**Great North Road Solar and Biodiversity Park EN010162
Post Hearing Submission from Nottinghamshire County Council
18th February 2026 (Examination Deadline 3)**

Nottinghamshire County Council (NCC) submits the following post hearing statement at Deadline 3. This statement is a written summary of the oral representations made by NCC at the hearings held during week commencing 2nd February 2026, supplemented with further clarification where necessary.

GENERAL ARRANGEMENT SCALE 1:2000

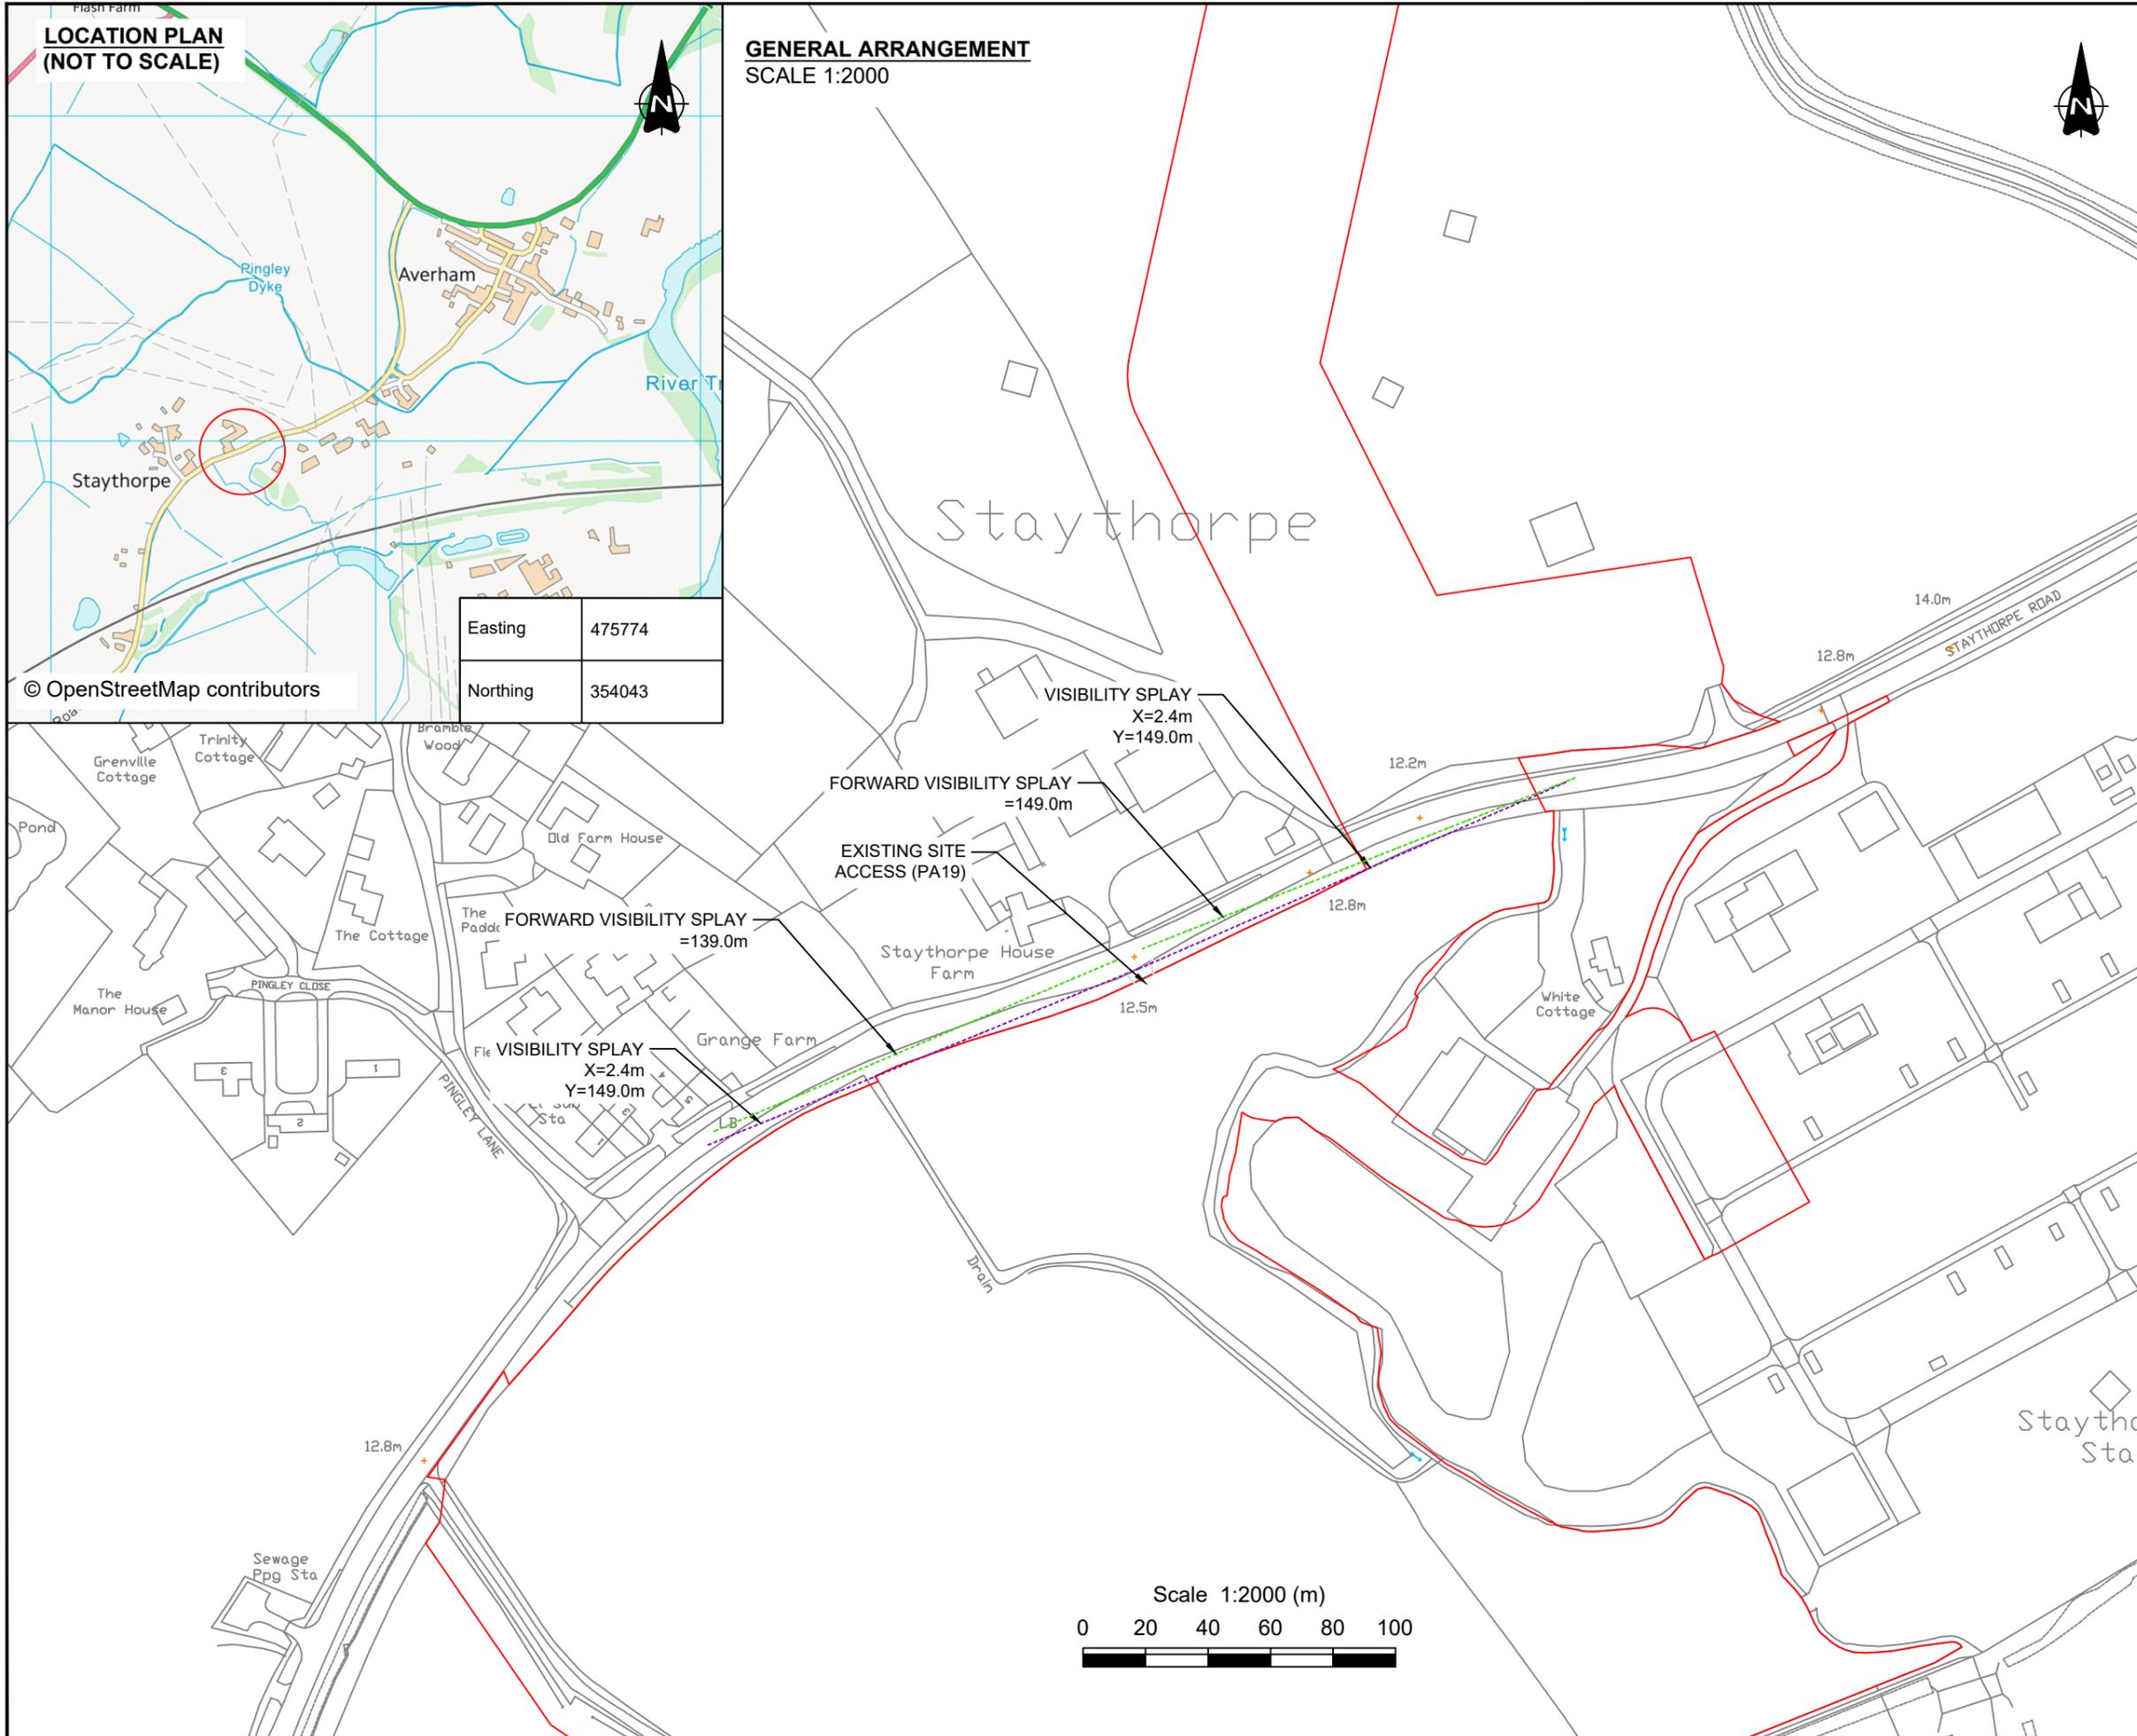
15. NCC advised that several of the proposed accesses which have been designated as temporary accesses should be made permanent because they would be the primary access point. In accordance with NCC's Highway Design Guide, where permanent access is required, NCC would expect their safety to be demonstrated through provision of adequate visibility splays supported by speed data and a Stage 1 Road Safety Audit prior to consent being granted, to ensure that they are acceptable in principle before they become fixed by the DCO. Full technical detail should be submitted for approval post consent, as outlined at ISH2 (see above), but technical detail matters would not override the principal of the location of the accesses which must be demonstrated prior to the order being made.

17. NCC is concerned that the visibility splays which have been provided to date may fall outside of the order limits and/or highway and therefore it is unclear how these could be maintained either by the developer or by NCC. It is critical that visibility splays are provided for each permanent access and passing place, alongside the order limits, in order to demonstrate that they can be maintained and, if necessary, the order limits can be modified. It would be too late for these to be provided post consent as part of the detailed design.

18. NCC acknowledged that the Applicant submitted additional visibility splay drawings at Deadline 2 however it is advised that several splays are missing and some have been drawn incorrectly. NCC confirmed it would be willing to discuss this further with the Applicant to ensure this is resolved.
19. NCC would highlight that in terms of residual effects, these are usually considered minor or negligible as the major highway impact should only be experienced during construction with such developments and generally manifest as delay and inconvenience. However, any failure to address these important design safety issues will result in moderate and potentially significant issues as the outstanding matters are safety matters, which could result in conflicts and collisions.
